MINUTES

Reference:	EN010092 Thurrock FGP
Meeting Name:	Round Table Heritage Meeting
Meeting date:	10 February 2021
Meeting location:	Via MS Teams

Figure 1.1: Representative Viewpoint Locations

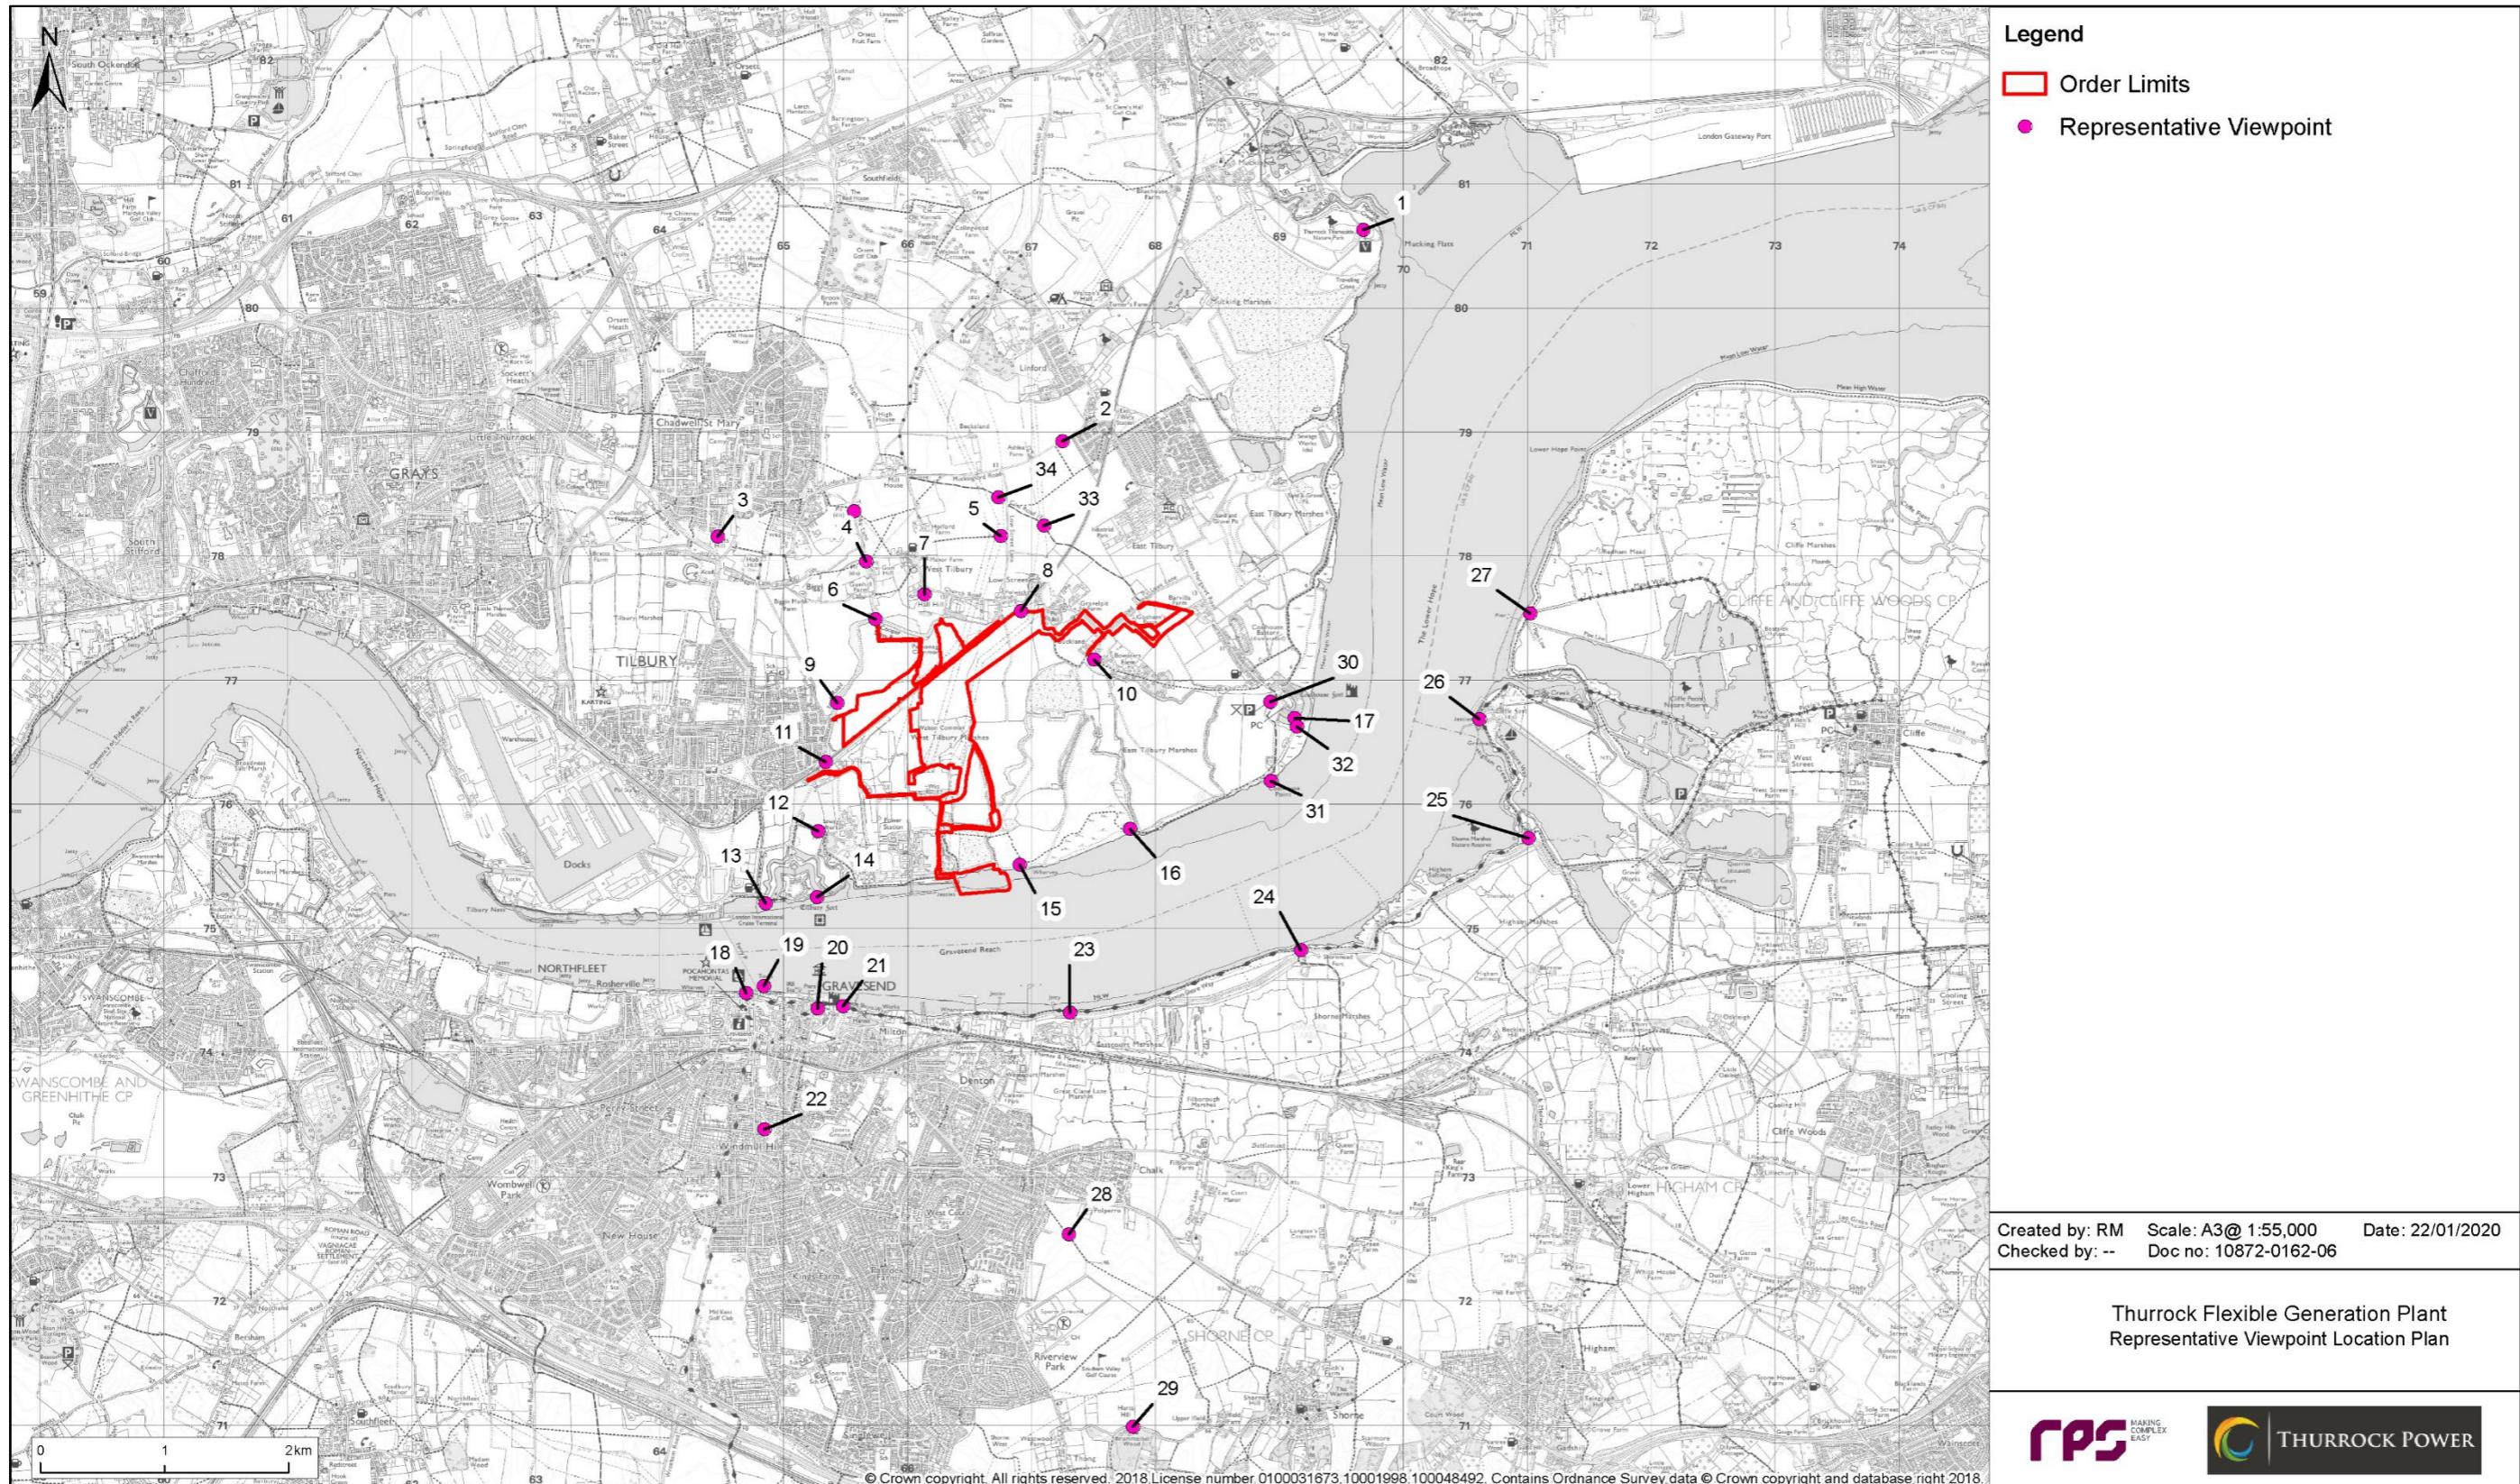
■ agreed on review that the difference in winter/summer foliage in views from relevant viewpoints (including 3, 4, 7, 8, 10, 13, 14, 17, 30-32) did not warrant reproducing the existing visualisations from these viewpoints on the winter photography base.

■ suggested three new baseline photographs should be taken:

- At Coalhouse Fort, slightly further west of VP31 at the corner/point on higher ground
- At St Catherine's Church, slightly further north of VP30 (subject to NC sharing further photos already taken at this location, which may indicate this is not needed)
- At Bowater's Farm AA Battery, insofar as feasible through the vegetation

■ requested that wirelines, cumulative wirelines and if appropriate photomontages (depending on level of development visibility, as indicated by wirelines) should be produced for each of these. ■ agreed.

- ■ **to take the three additional photographs and produce visualisations for them as listed above**
- **This information to be provided to the examination**

Viewpoint 24
Figure 1.9

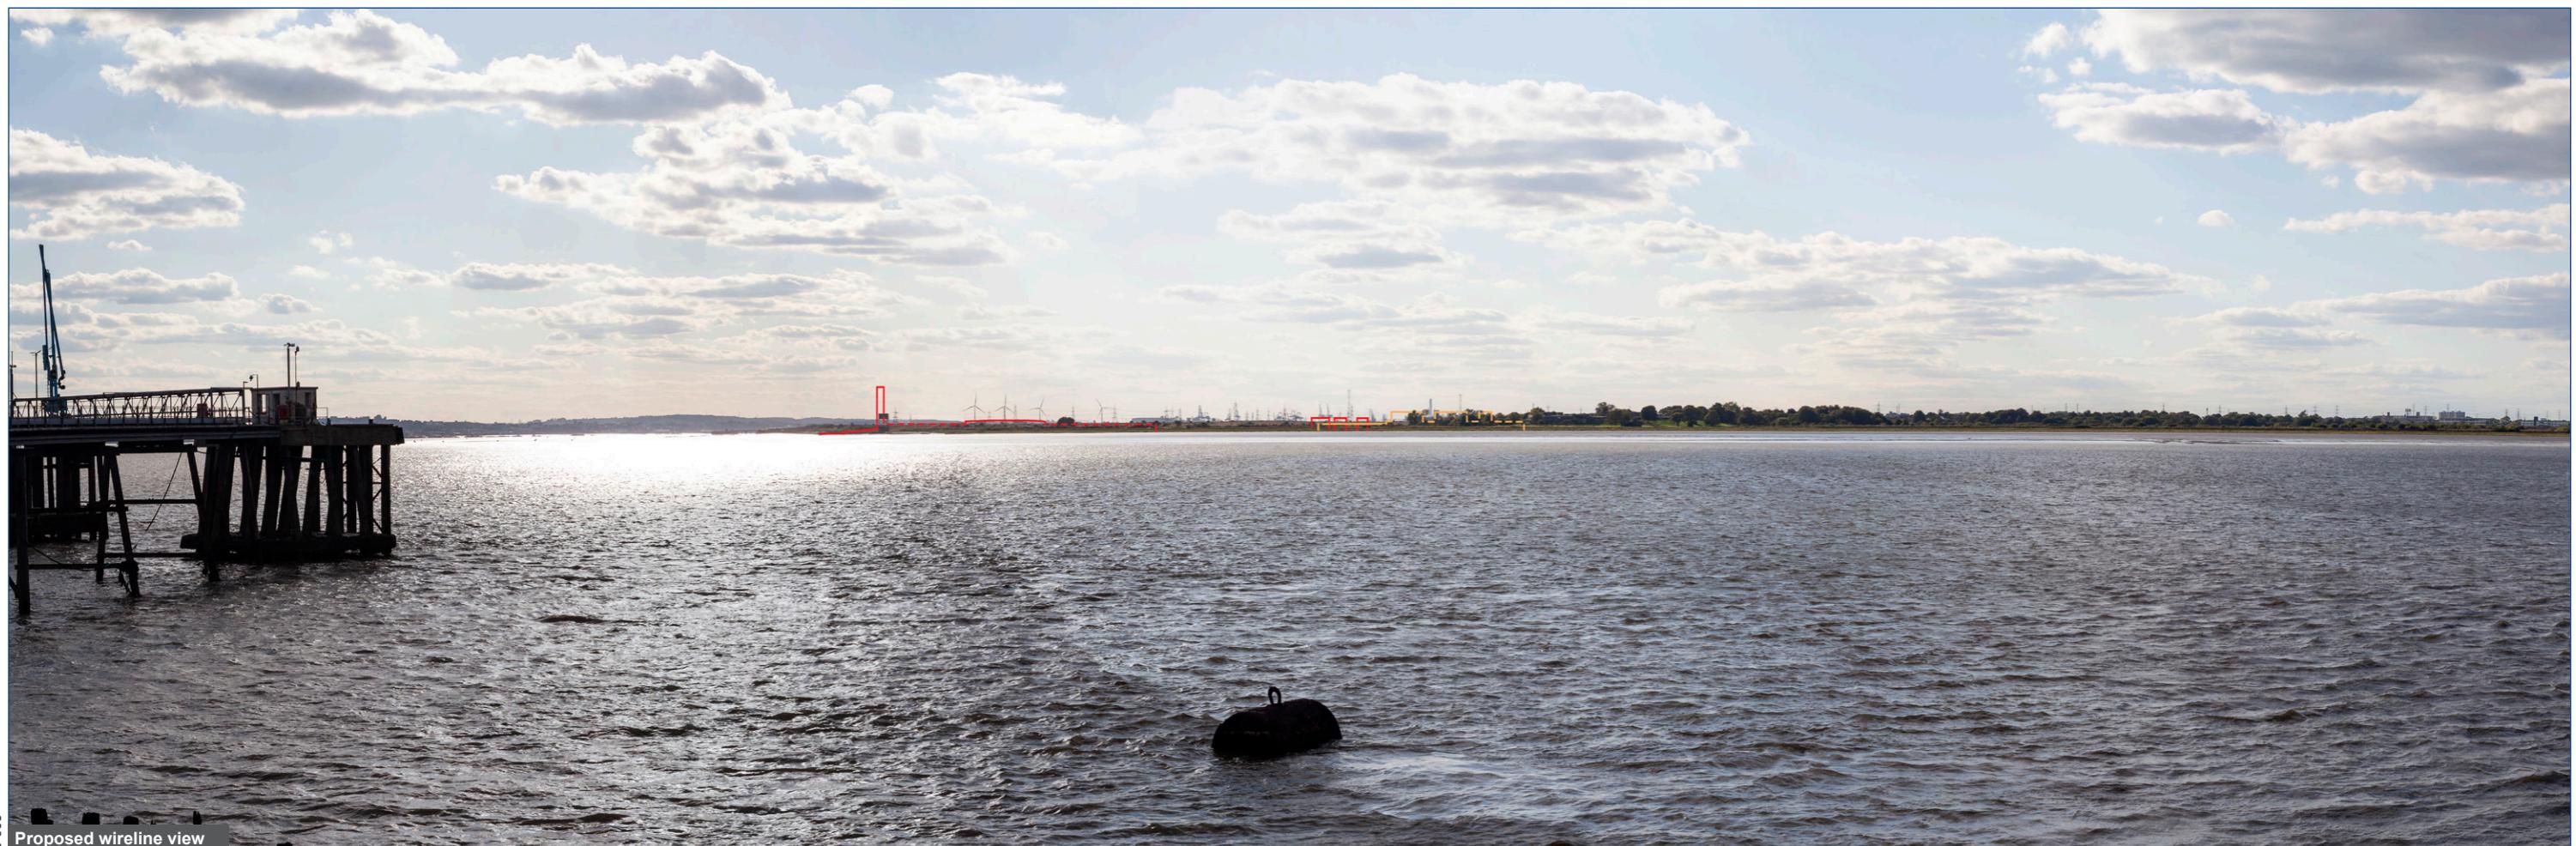
■ confirmed that wireline and photomontage had been submitted for VP24 (Shornemead Fort)
